Submission No.			121		
Organisation Name or Name of Submitter			Iarnród Éireann		
Item No.	Section Ref.	Page No.	Observation Statement	TII Response	
IÉ Observations (for submission to ABP) relating to MetroLink Railway Order application - 11 th January 2023					
1	Cover letter - IE Observations	1	While land required for the purposes of transport services may be included in a Compulsory Purchase Order application, Section 130 of the Transport Act 1944 precludes the compulsory acquisition of such land without the previous consent of the Minister for Transport.	TII agree with the interpretation of Section 130 of the Transport Act 1944 which as correctly stated precludes the compulsory acquisition of such land without the previous consent of the Minister for Transport. Accordingly, if the Railway Order is confirmed, and the CPO is granted, no Notice to Treat will be served without Ministerial consent. As is normal practice TII will enter into an agreement with CIE / Irish Rail, at the appropriate time, that addresses and deals with any and all land consideration requirements and which allows for any such consents to be made available on receipt of an Enforceable Railway Order.

Drawing Title	METROLINK GLASNEVIN HEAVY RAIL TRACK REALIGNMENT	Drawing Status	S0
Drawing N°	ML1-JAI-SRD-MS11_XX-DR-Y-01001	Plan Drawing N°	ML-ST 304 N-09
Scales	Original Size A1 AS SHOWN	Sheet	1 of 5

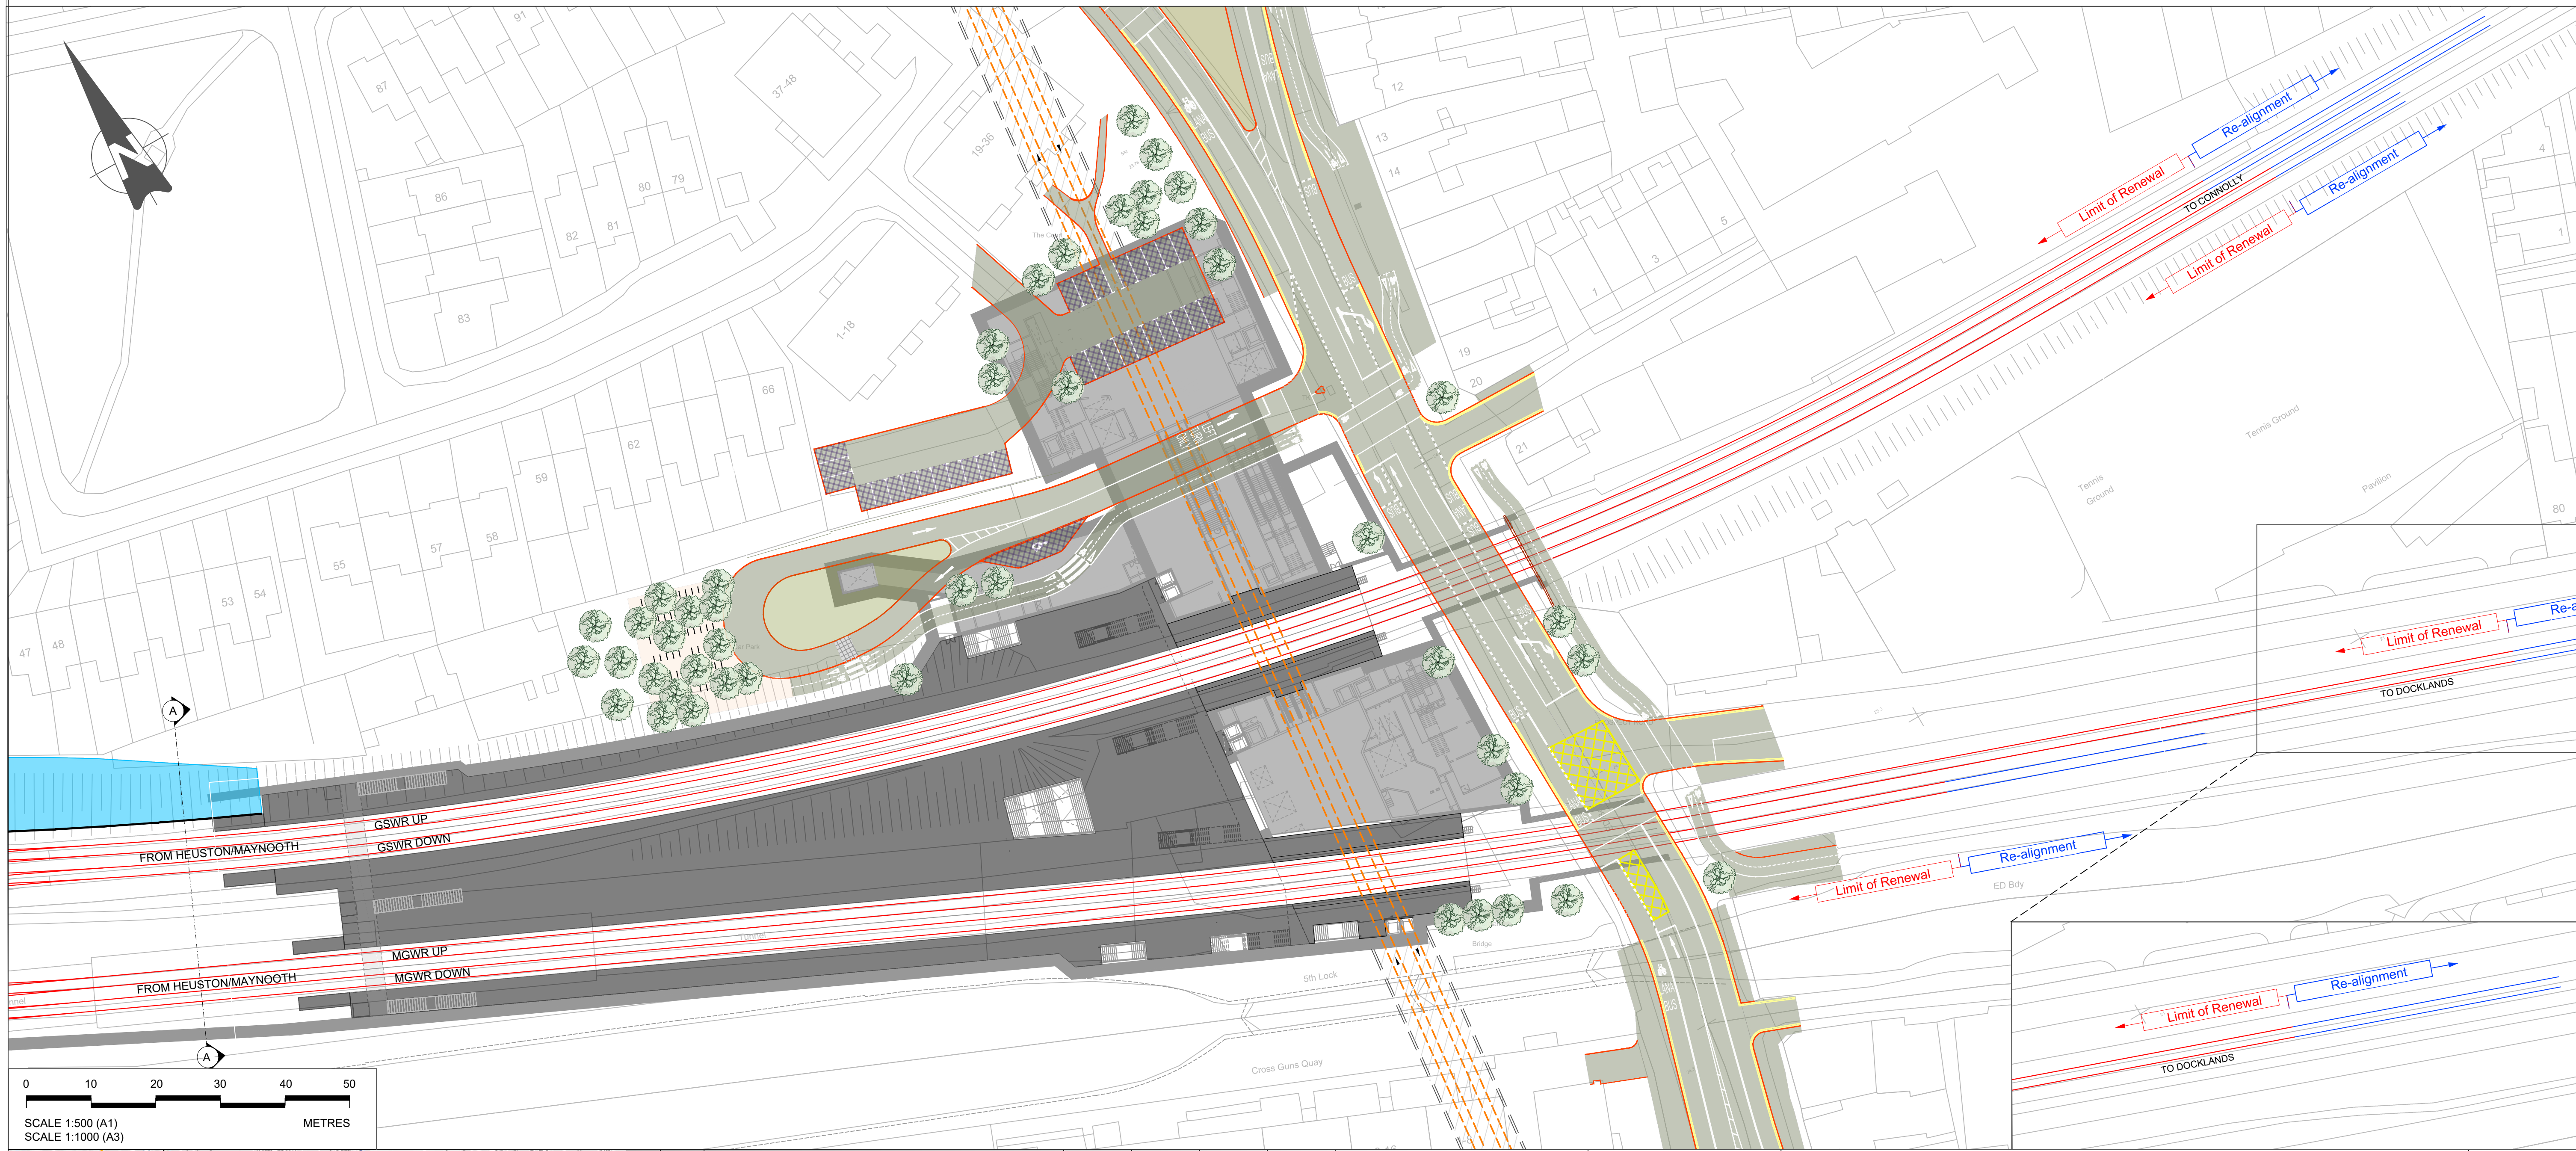
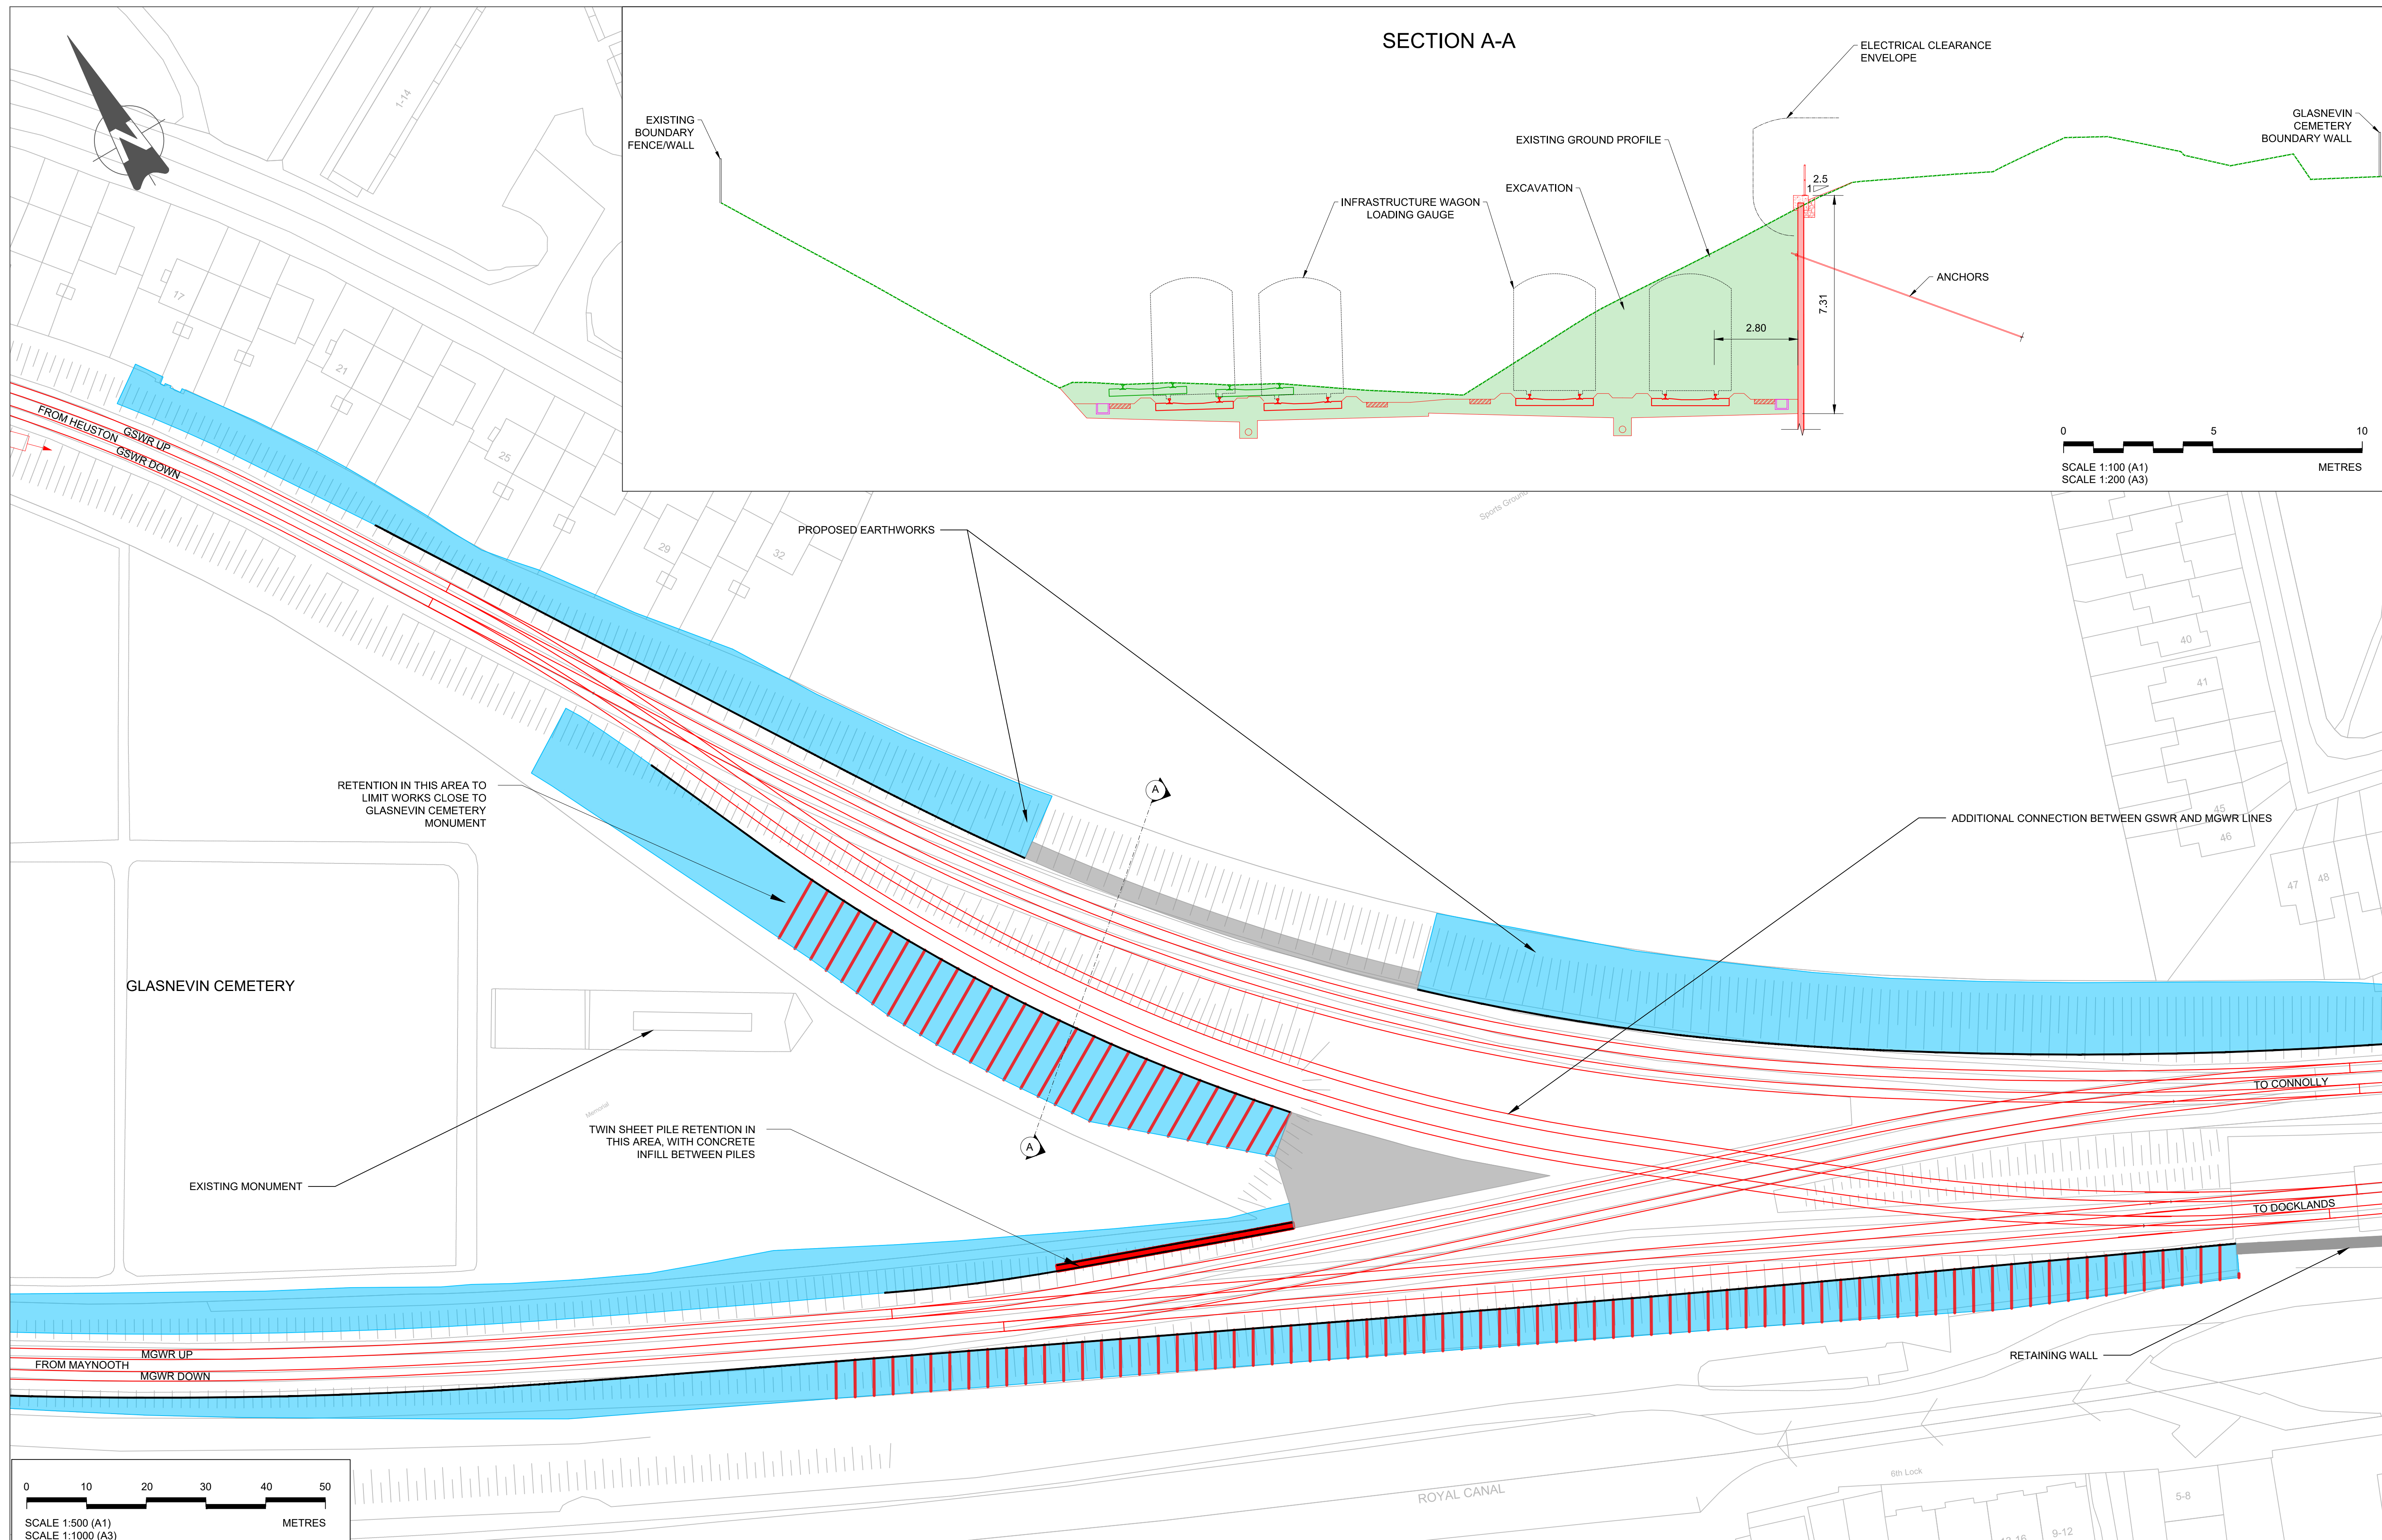
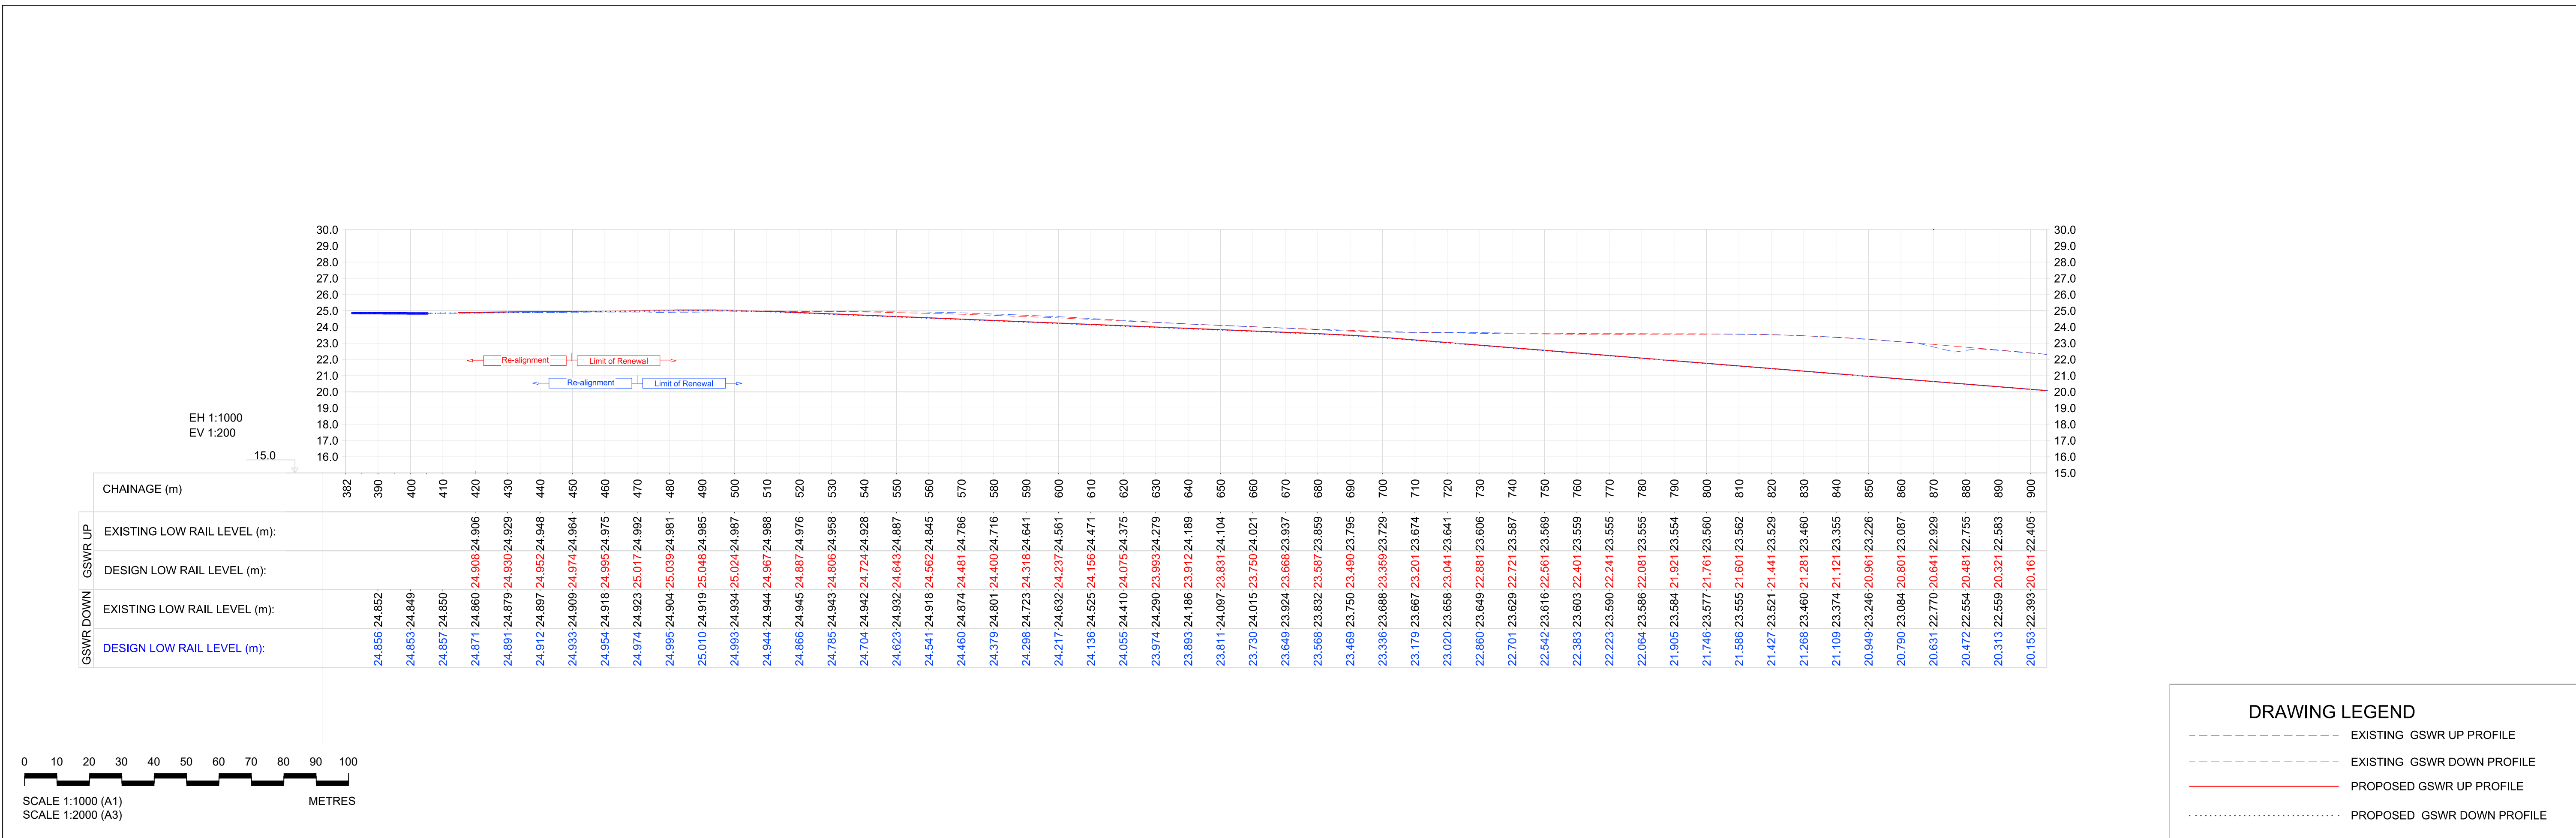
3	Glasnevin Station 1	1	1. While it is understood that Metrolink construction will be impactful on Iarnród Éireann services and our customers, every effort must be made to minimise those impacts. The prolonged closures of the MGWR and GSWR lines proposed by TII at Glasnevin, of 21 and 5 months respectively, to allow the construction of the Glasnevin Station for Metrolink will cause significant disruption to Iarnród Éireann passenger, freight and maintenance services.	The works at Glasnevin are extremely complicated and will require a coordinated approach to ensure successful delivery, particularly given the physical constraints associated with the railway, the canal and fronting residential properties. TII has developed a plan that incorporates a possession regime based on the preliminary design and programme assumptions which were discussed in detail over a number of years with both Iarnród Éireann and the National Transport Authority. The plan is designed to ensure that the works can be delivered safely and efficiently. TII does acknowledge that the plan will lead to disruption of the existing services and will impact on customers. However, TII believe that the planned closures described in the EIAR Chapter 5, MetroLink Construction Phase, Section 5.10.6 and Appendix 5.5 – Glasnevin Station Construction Report, which are 21 months for the Western Commuter Line (Maynooth to Docklands) Midland Great Western Railway (MGWR), and 5 months for the Southwestern Commuter Line, Great Southern and Western Railway (GSWR), represent a worst case construction and customer service impact. TII have been working closely with Iarnród Éireann and the National Transport Authority with a view to reducing the overall duration and impact of the required mainline rail closures, and confirms that every effort will be made to minimise the impacts on the passengers services, especially connection to Connolly station. It is worth noting that during the works taking place on MGWR all trains can still travel to Connolly Station. In both circumstances there will be a number of temporary closures occurring at night-time and weekends fo facilitate track lowering work. TII welcome further discussions with Iarnród Éireann to coordinate any requirements to be included in the main works procurement process and Contract with a view to minimising impacts.

4	Glasnevin Station 2	2	2. Iarnród Éireann is firmly of the view that the prolonged closures proposed are excessive and that, coupled with an appropriate short term track possessions regime, significantly shorter closure periods should be feasible. The disruptive impacts to train operations must be minimised and timed for periods of lower passenger and freight usage on Iarnród Éireann services e.g. summer months.	Please refer to Response (3) above.
